Dart + submission

Paul Donnelly TD

Coolmine Level Crossing: Description of the Railway Order Proposals

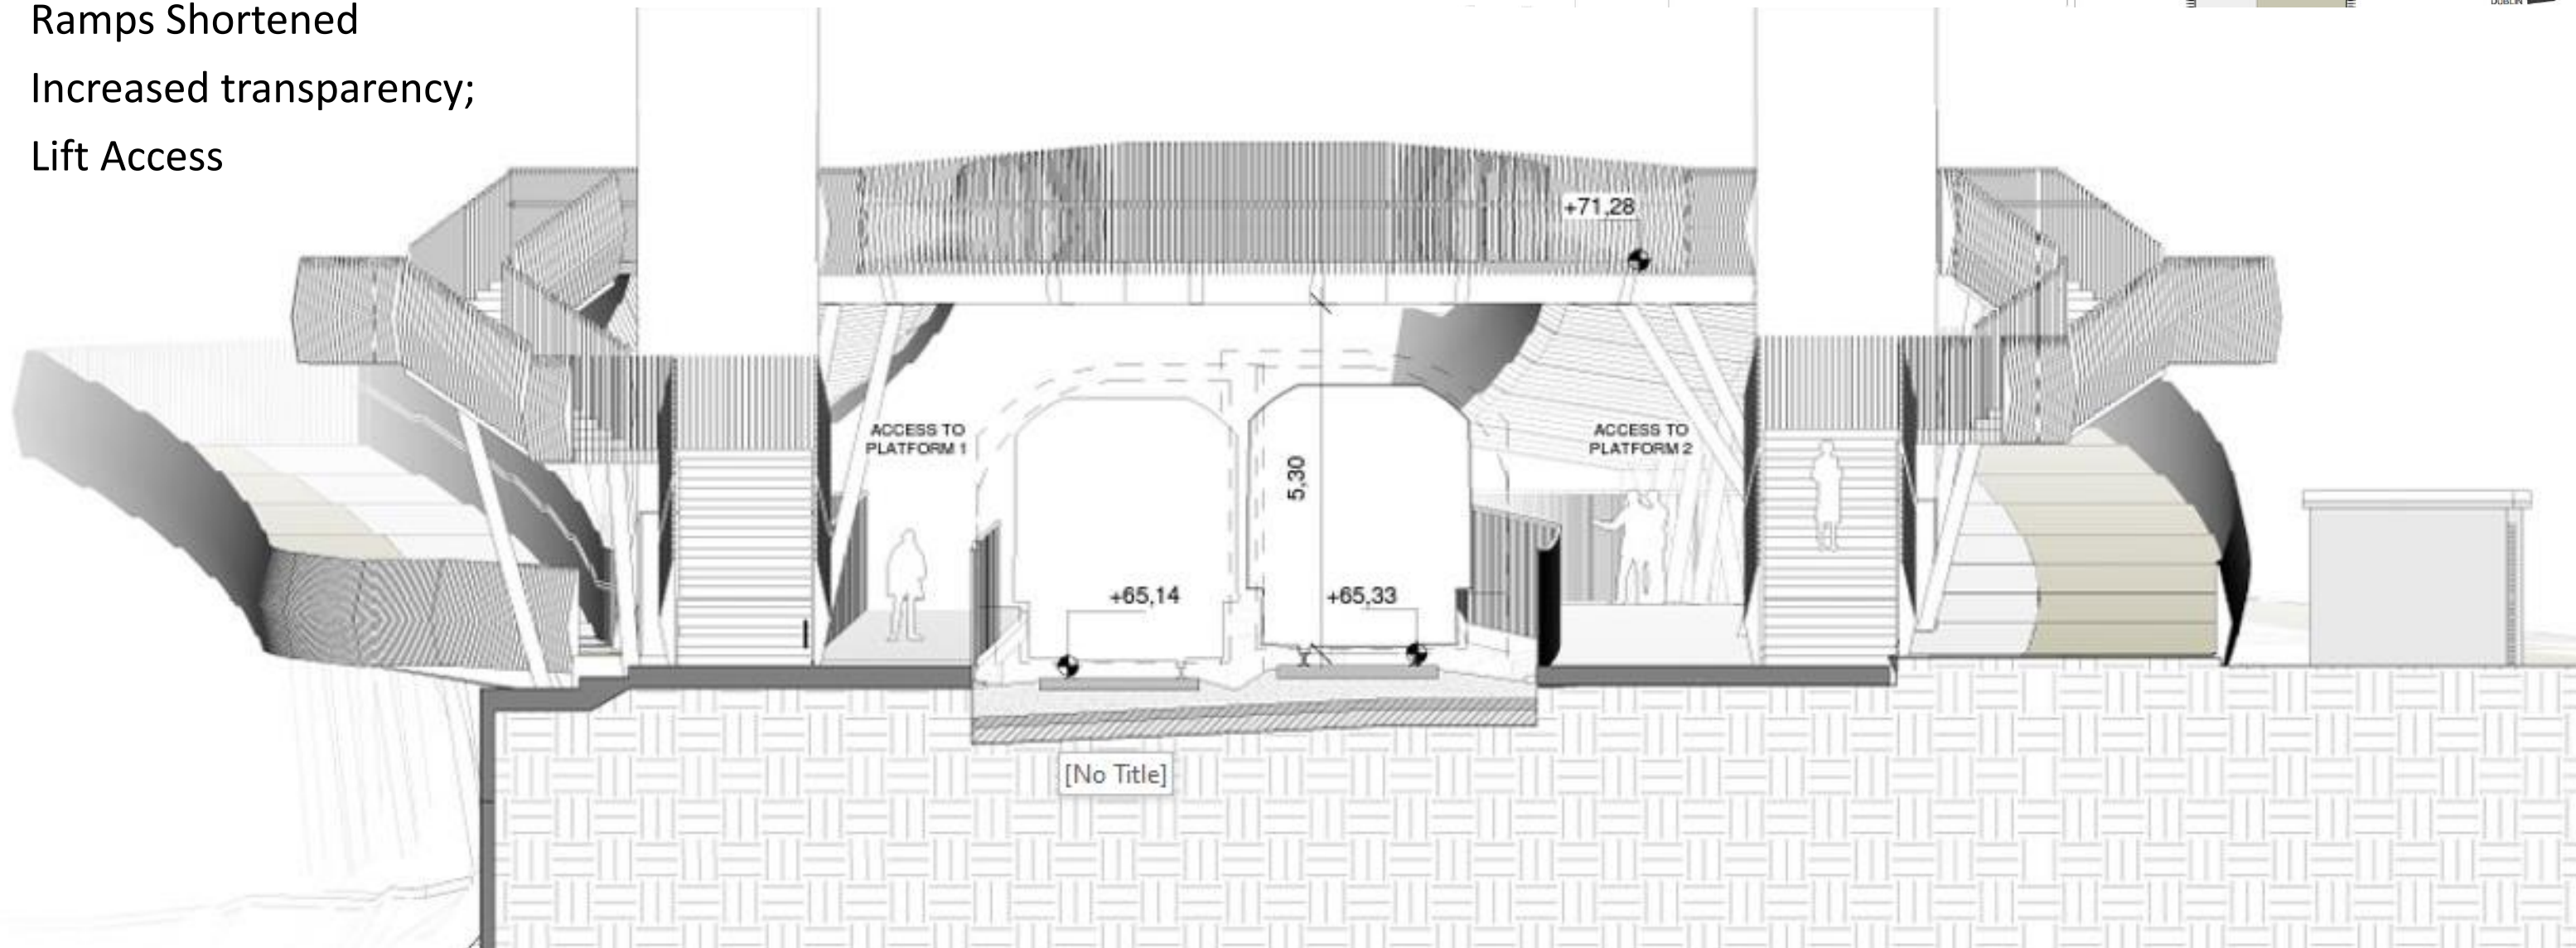
I have concerns around the Granard bridge section of the proposal. I cannot see how the upgrading of this will in anyway help the progression of traffic back and forward across the bridge. It must be noted that there will be no crossings whatsoever from Clonsilla village along the Clonsilla road down towards Roselawn and indeed this has the potential to effectively cut the community on the Castleknock side away from the western side.

I am also puzzled that there are no proposals whatsoever to jointly work with Fingal CC to install a new pedestrian or cycle way across the Granard bridge. This would be a serious mistake and it would be bizarre that the opportunity would not be taken to install such facilities thereby making cycling and walking safer and possibly reducing the need for cars, which is the very reason why the Dart + project is taking place.

Finally, Residents have expressed concerns around the potential for anti social behaviour if the area on the Coolmine side of the crossing is turned in to a de facto “cul de dac”.

# Ashtown

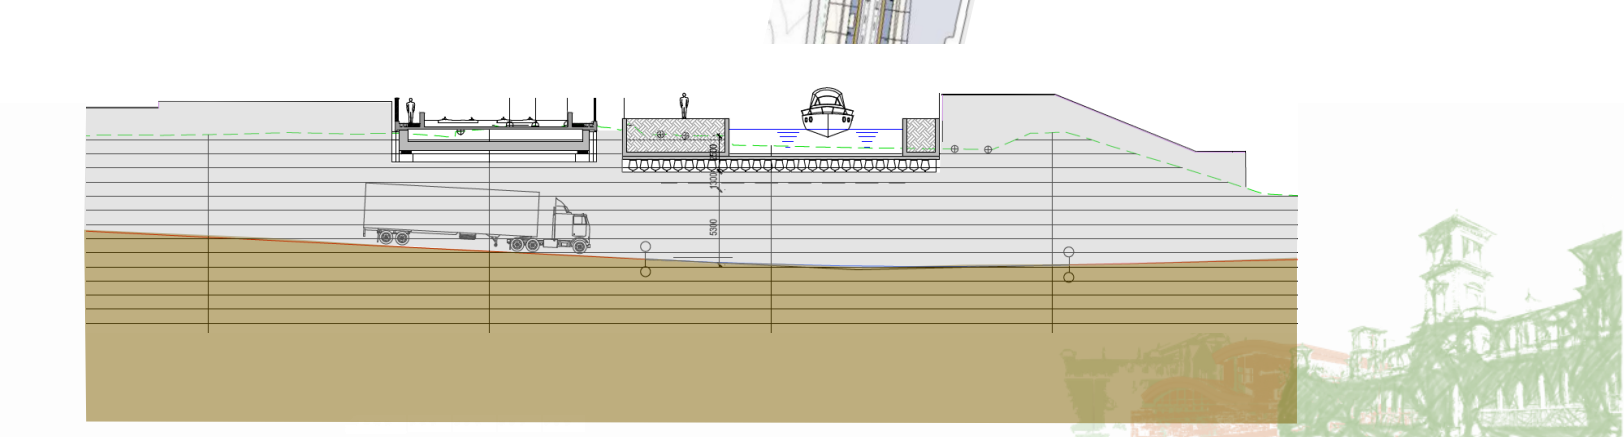
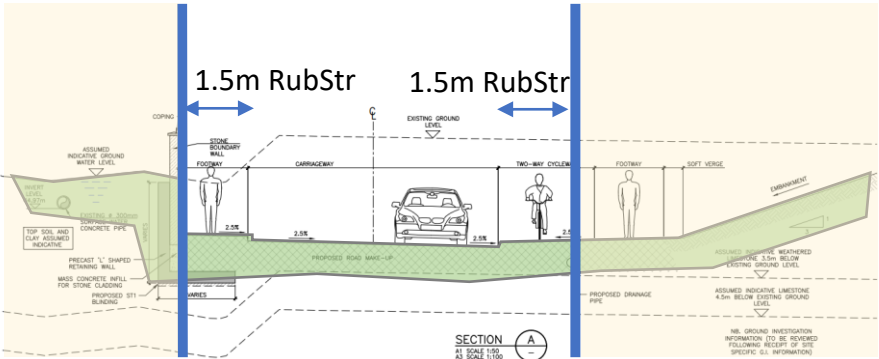
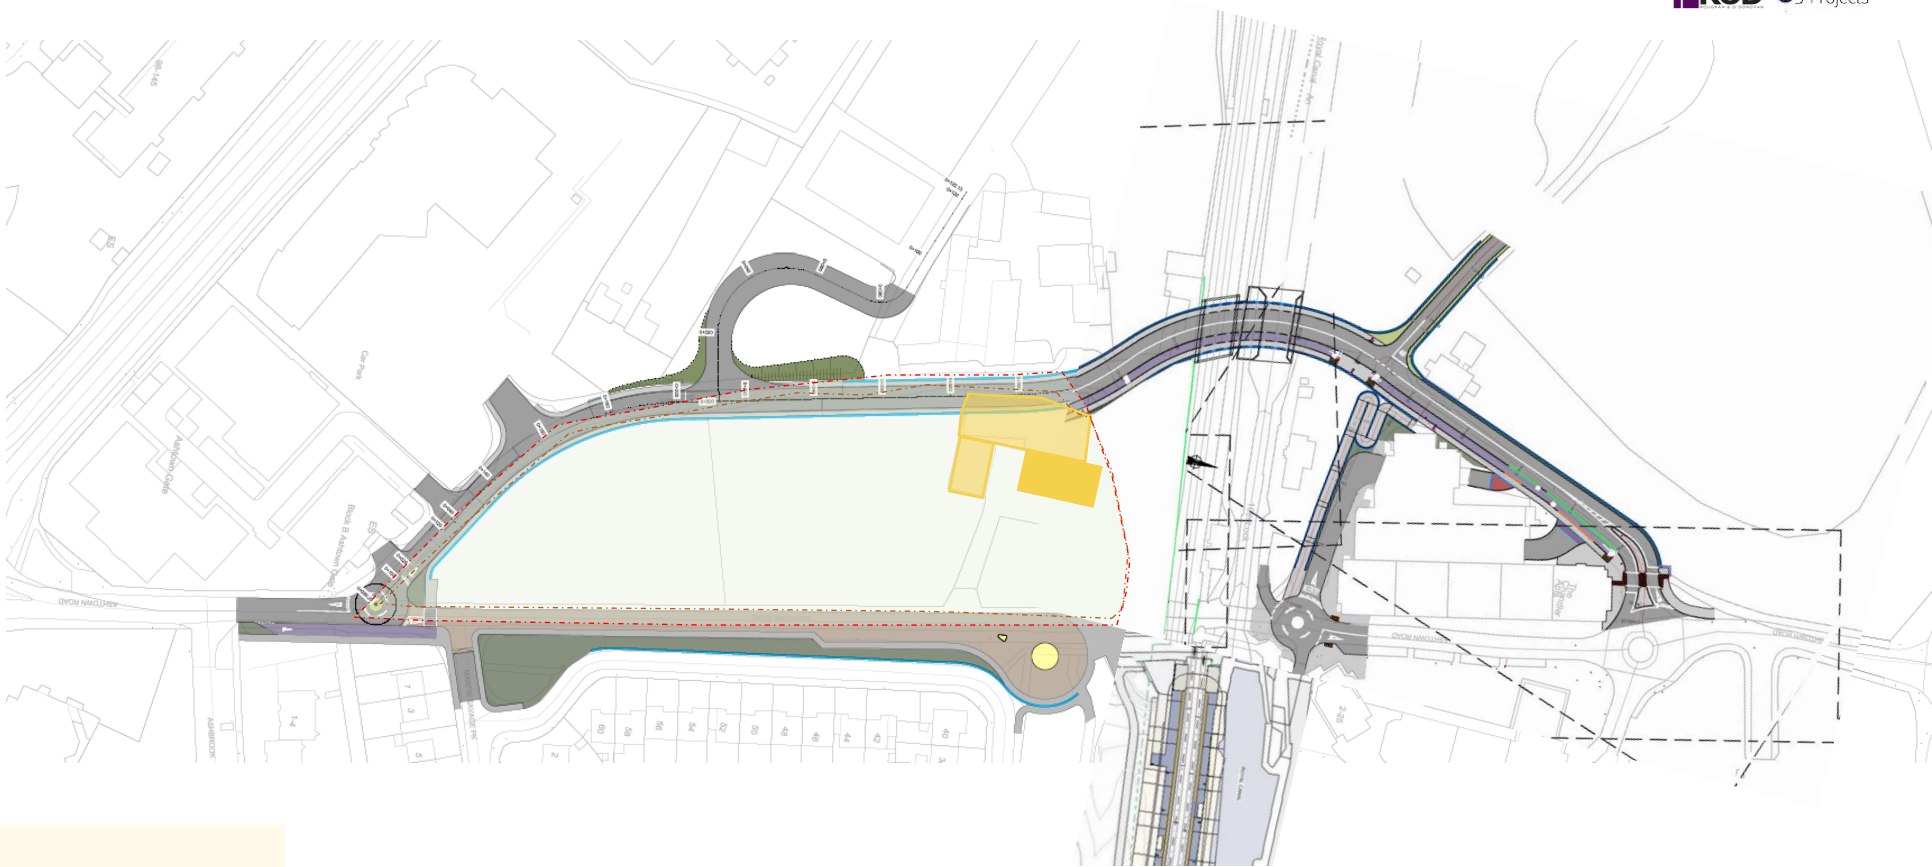
I note that the latest plan from Irish rail has excluded a lift at the existing level crossing, this is hopefully just an error. Many of those on the Navan roadside and in particular Martin Savage Park would be long time residents and would find it difficult to access their new village in Rathborne. They would feel they are cut off from their services.

On the issue of the tunnel/underpass, I have a concern that this will have a serious impact on local community. It has been stated that this will be unusable and indeed dangerous for pedestrians and cyclists and will be too far away from local houses to enable people to feel safe using it. I think this could be resolved with the installation of CCTV on the under pass.
